CITY OF ALBUQUERQUE

**Re: Starbucks
1000 Rio Grande NW
Request 30-Day Temporary C.O. - Accepted
Engineer's Stamp dated: 6-17-15 (H13D021)
Certification dated: 3-24-16**

1000 AND 1010 RIO GRANDE BLVD., NW GRADING AND DRAINAGE PLAN

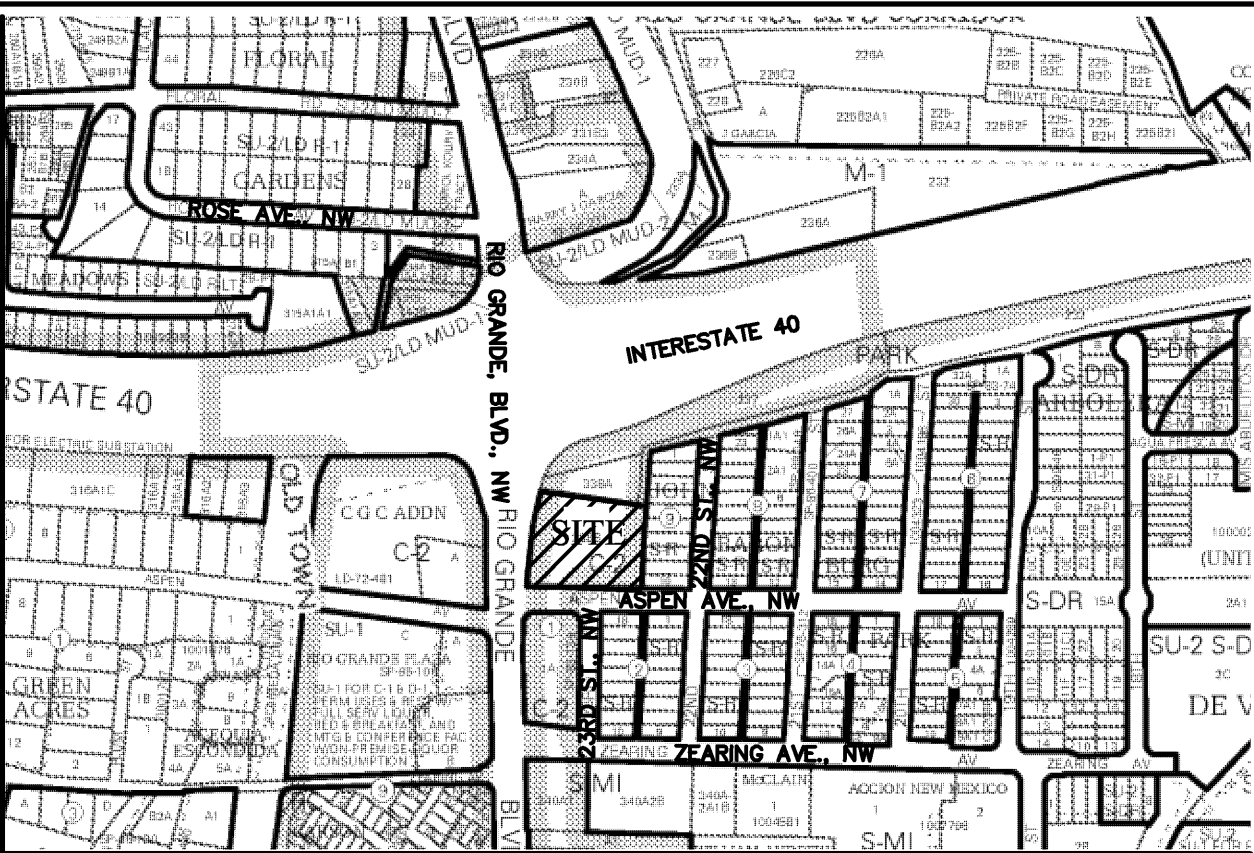
- The sidewalk on the south side of the building was not as-built on the drawings. Sidewalk is blocking flows to pond. Provide pipe underneath or sidewalk culvert.
- Transformer is on a mound that is diverting flows to the south and not into pond 'A'. A landscape water valve box is blocking flows into pond 'A'.
